A303 Sparkford to Ilchester Dualling Scheme TR010036

8.3 Draft Statement of Common Ground with Historic England

STATEMENT OF COMMON GROUND

Version	Date	Status of Version
Rev A	January 2019	Submission for Deadline 2

A303 SPARKFORD TO ILCHESTER DUALLING
WORKS PLANS REGULATION 5(2)(J)
SHEET 3 OF 4

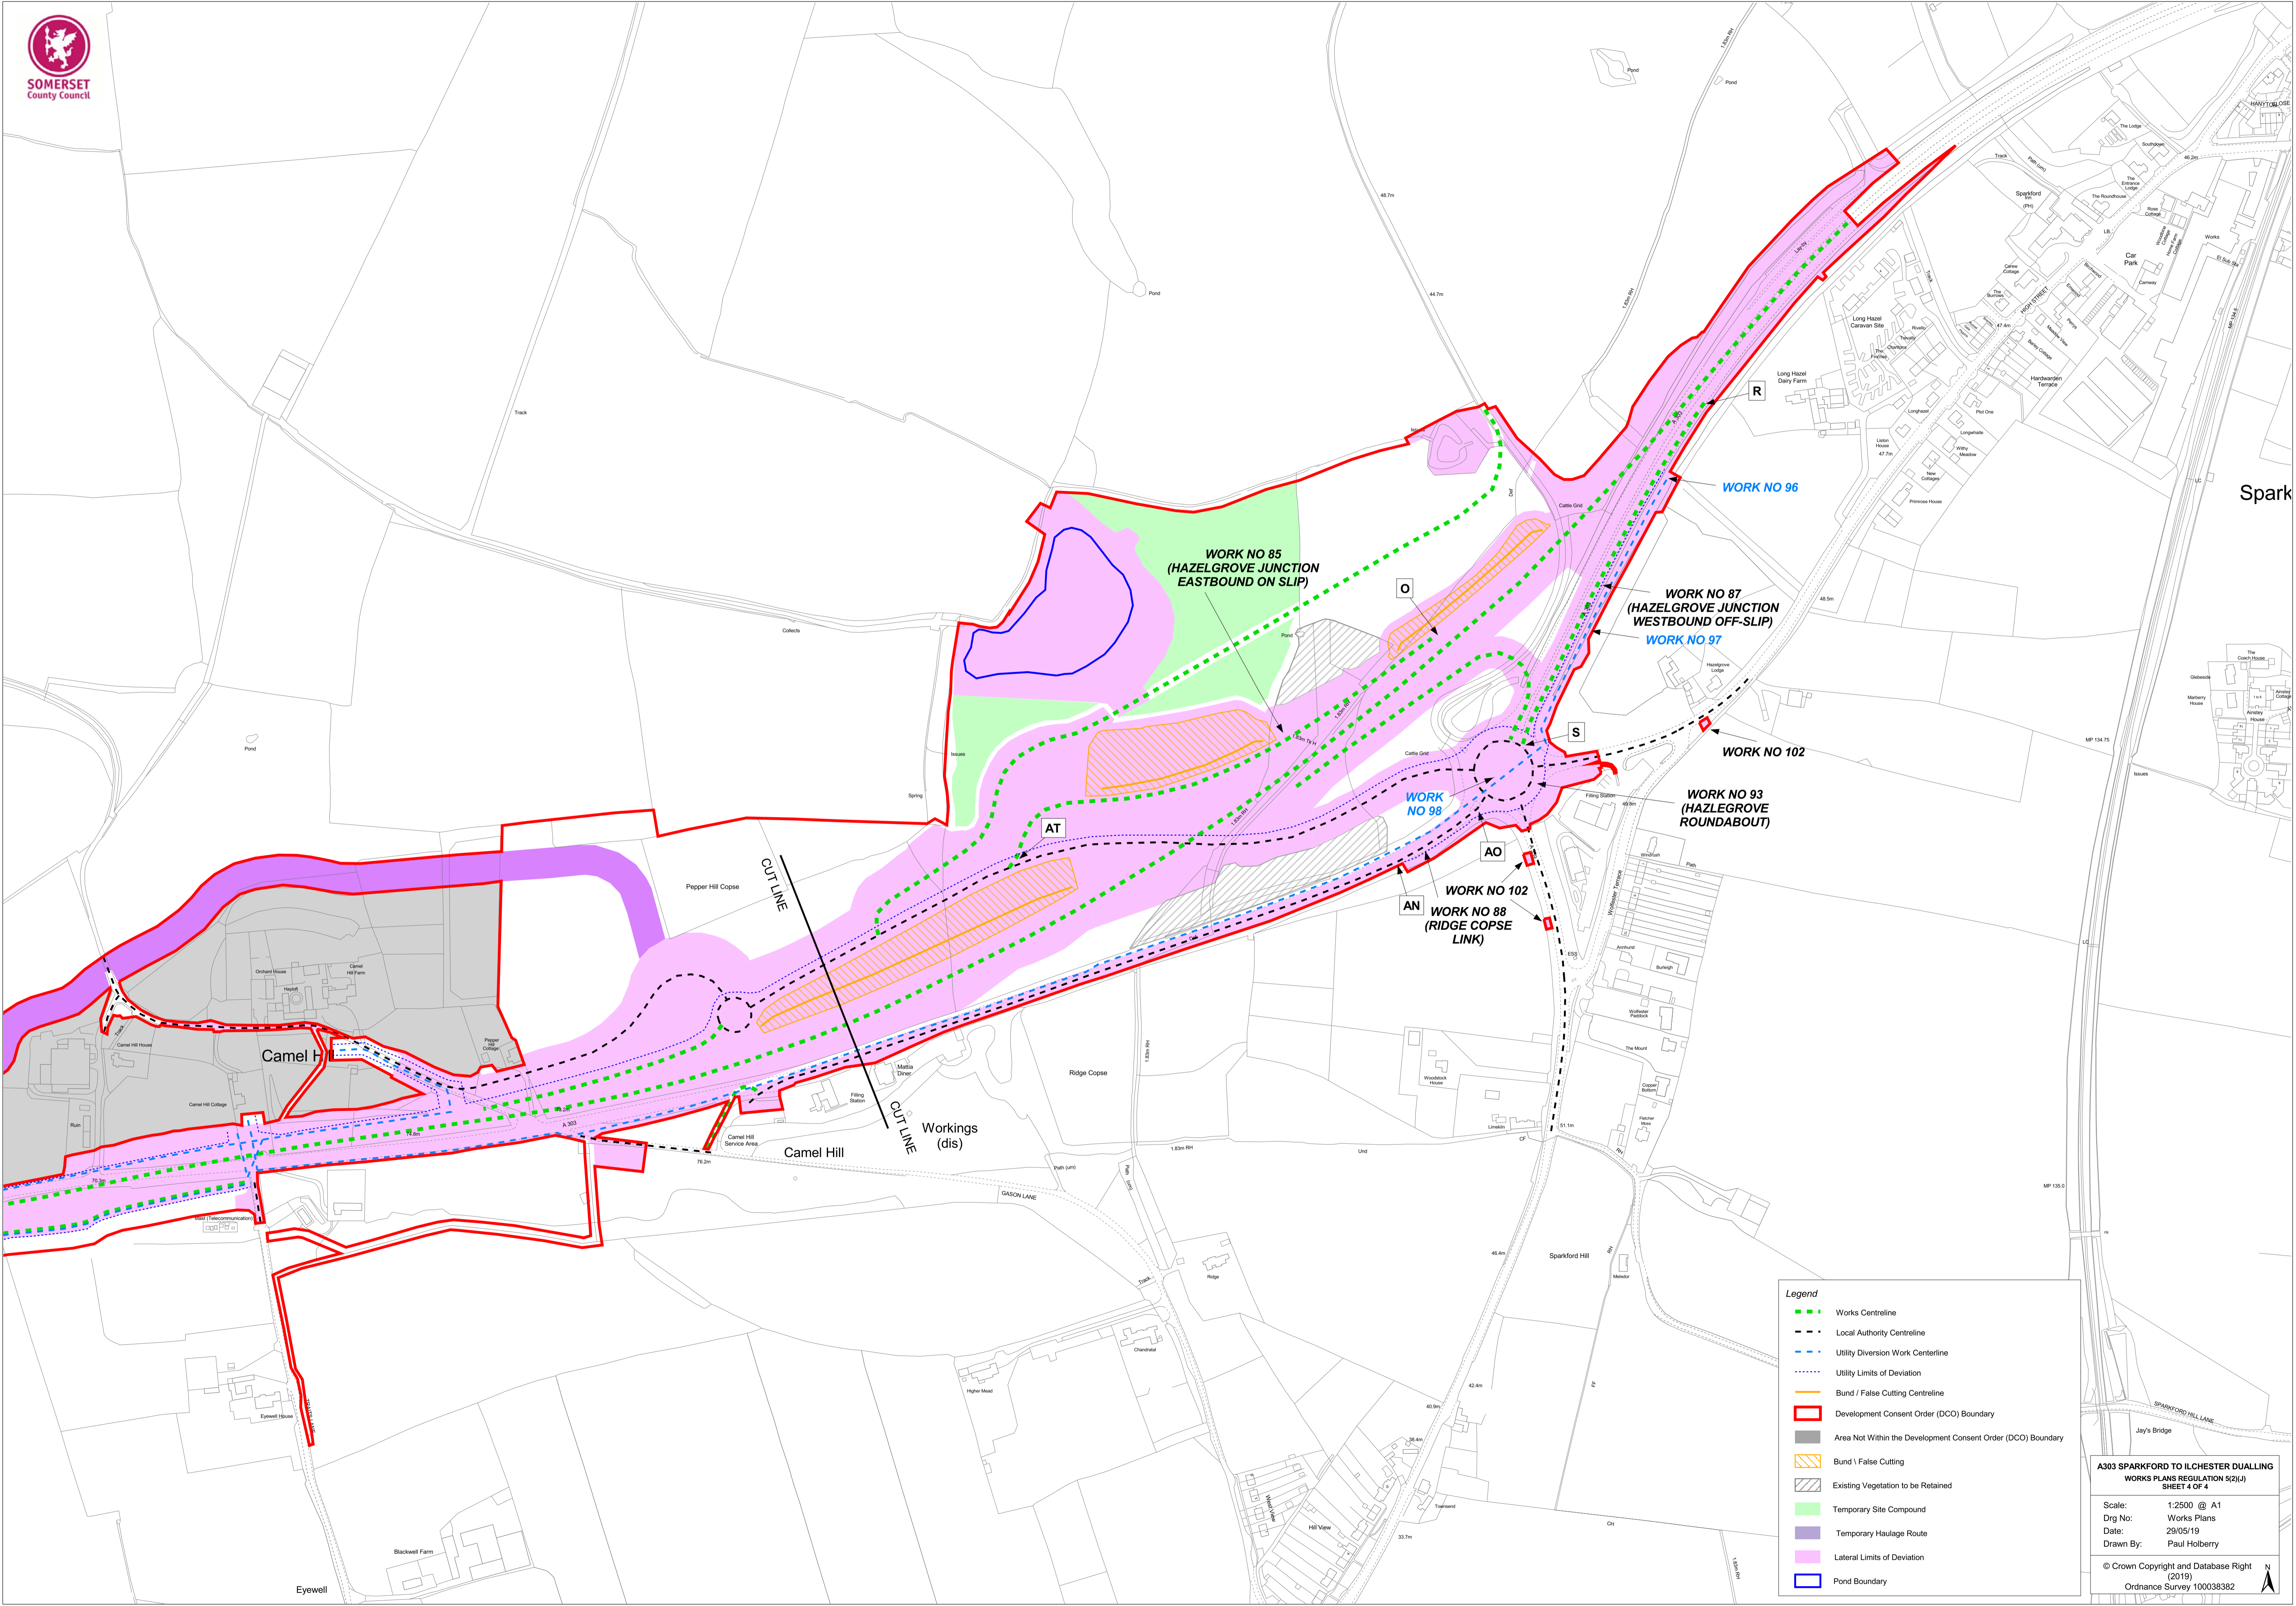
<p>HBMCE would welcome confirmation from the Applicant that the limit of lateral deviation included on the Works Plans (Sheet 3 of 4) will not entail encroachment within the Camel Hill scheduled monument.</p>	<p>A response will be prepared and discussed with HBMCE.</p>	<p><i>UNDER DISCUSSION</i></p>
